ATTACHMENT A – DETAILED RESPONSE TO SUBMISSIONS TABLE

Table 1 – Record and response to submissions to SSD 10822510

Level 08	
scale	1 : 250@A1
drawn	TH
checked	JC
project no	190551.00
drawing no.	DA1009
issue	D

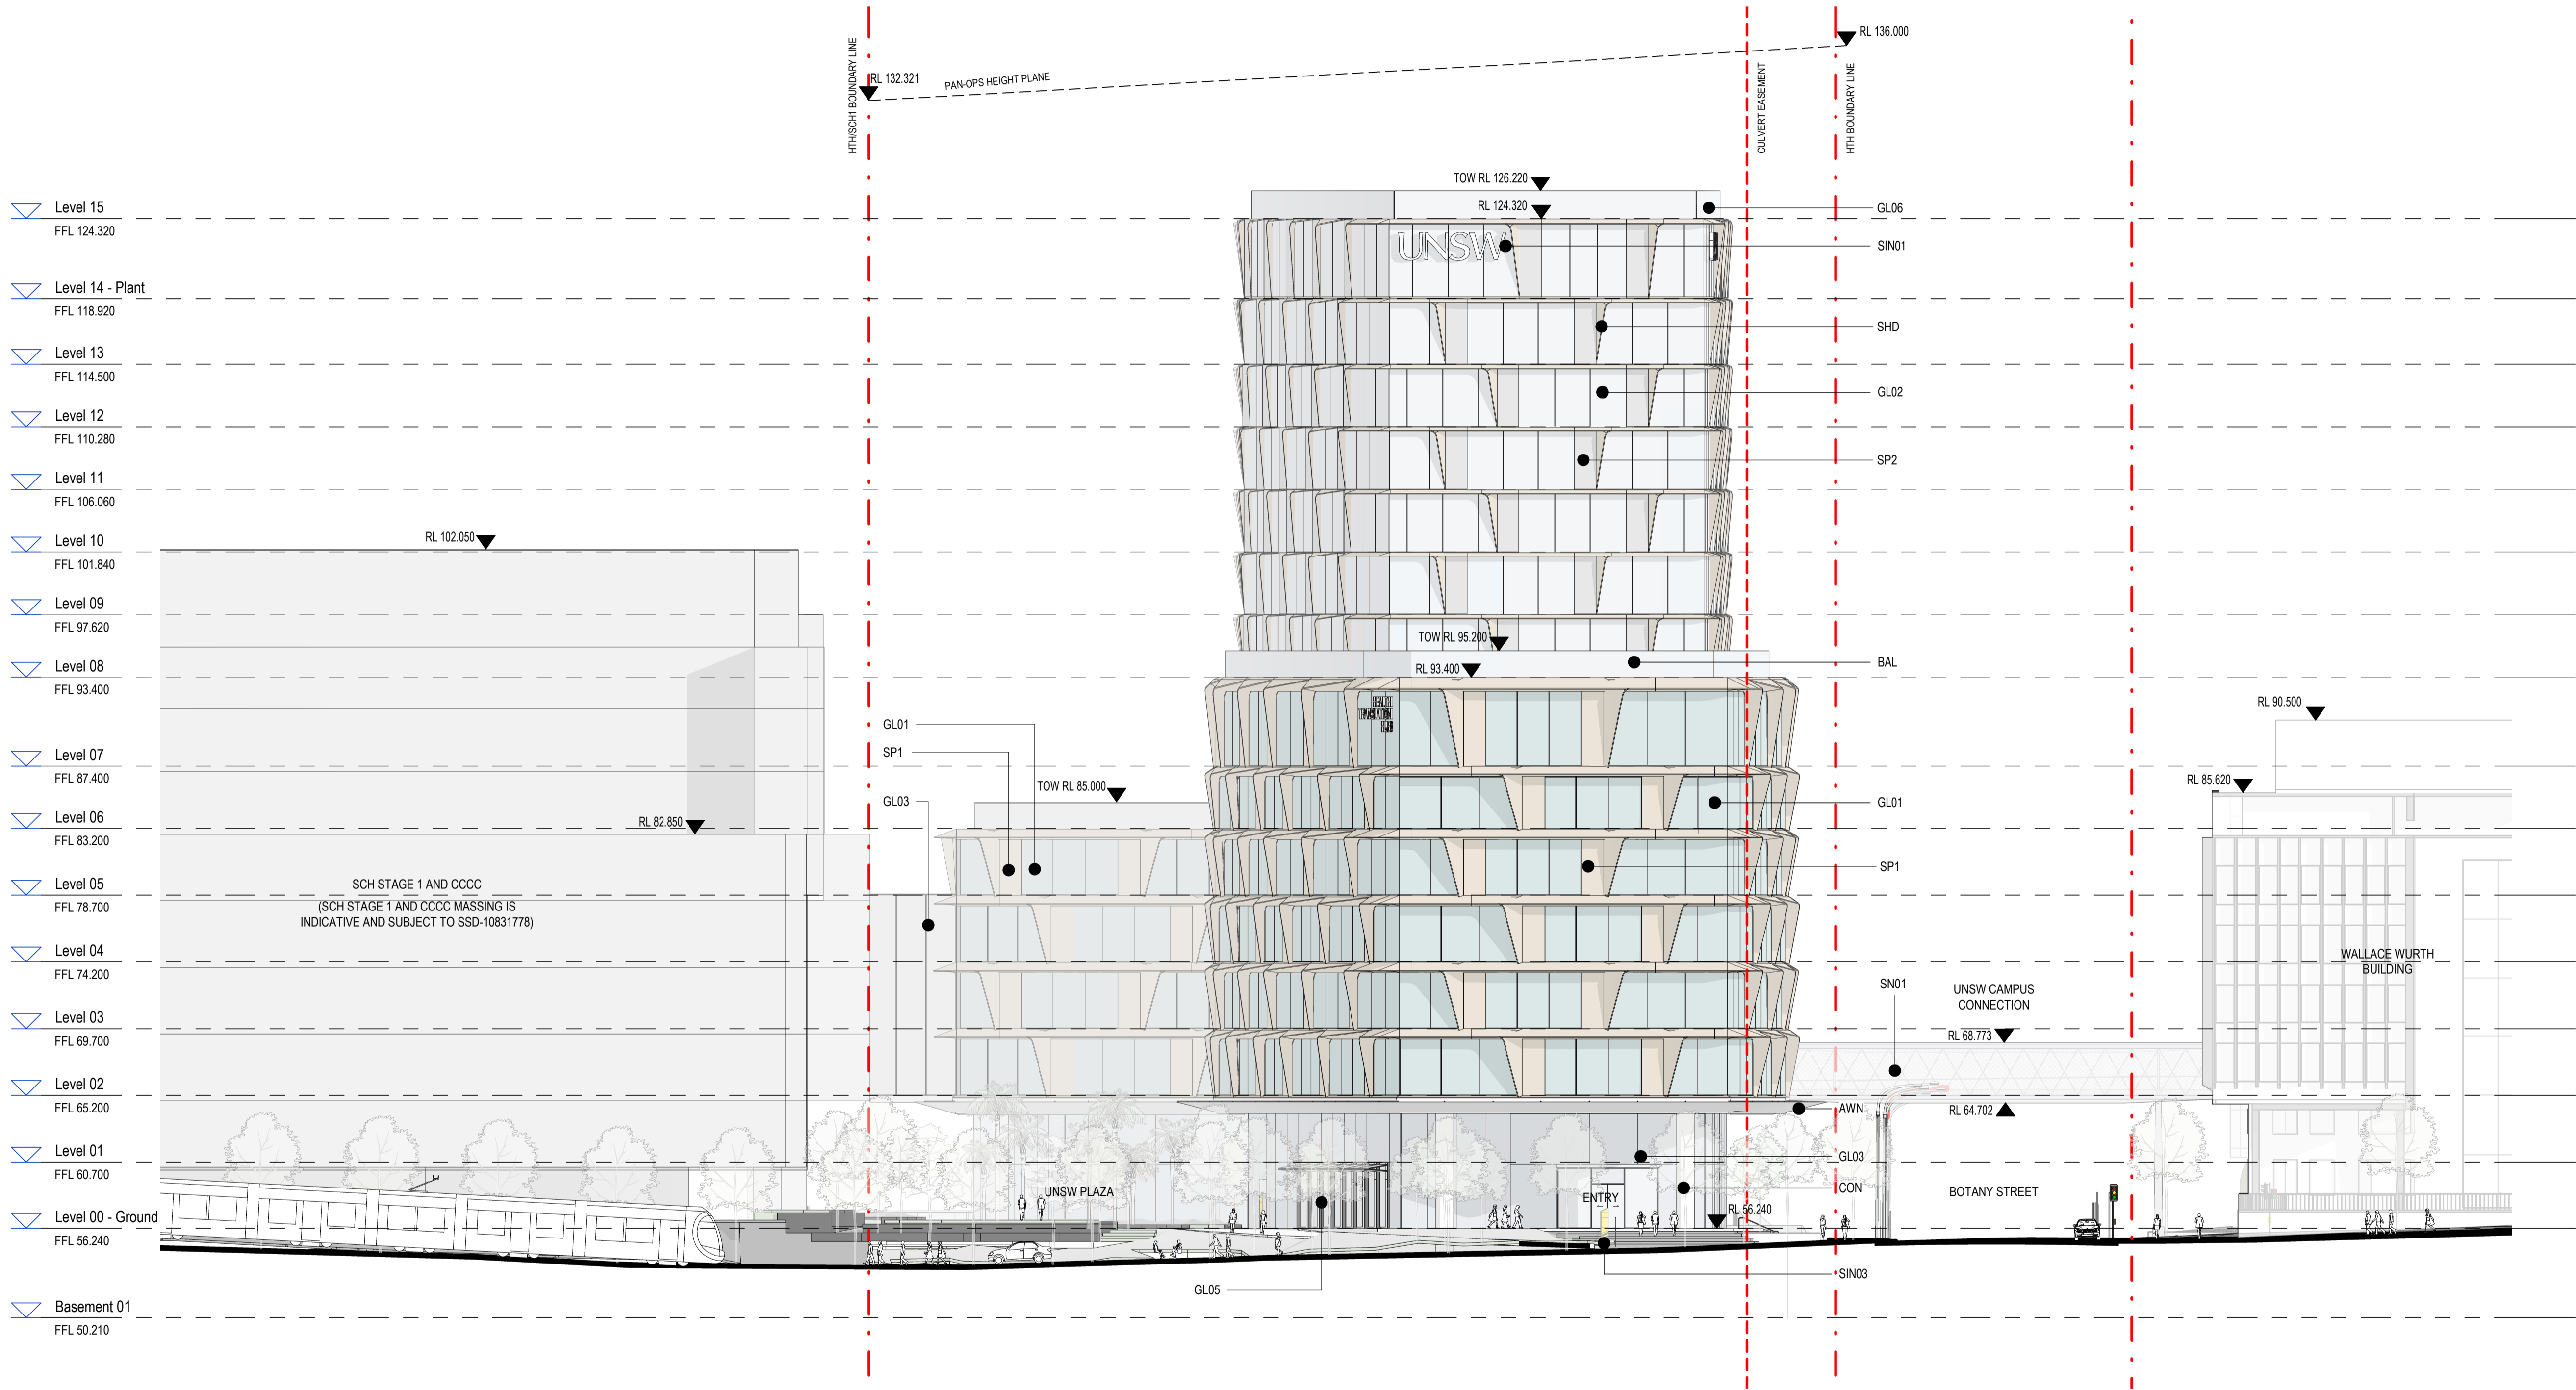
40			<p><i>The ESD Design Report states that renewable energy could be generated onsite through the provision of roof area suitable for solar PV integration, however the actual location of the proposed 100 kWp PV system has not been specified in the ESD Design Report. This should be a key element in the buildings design and should be included within the design at the assessment stage.</i></p>	The PV Cells were shown on the Level 15 – Roof Plan (DA1016) of the submitted application.
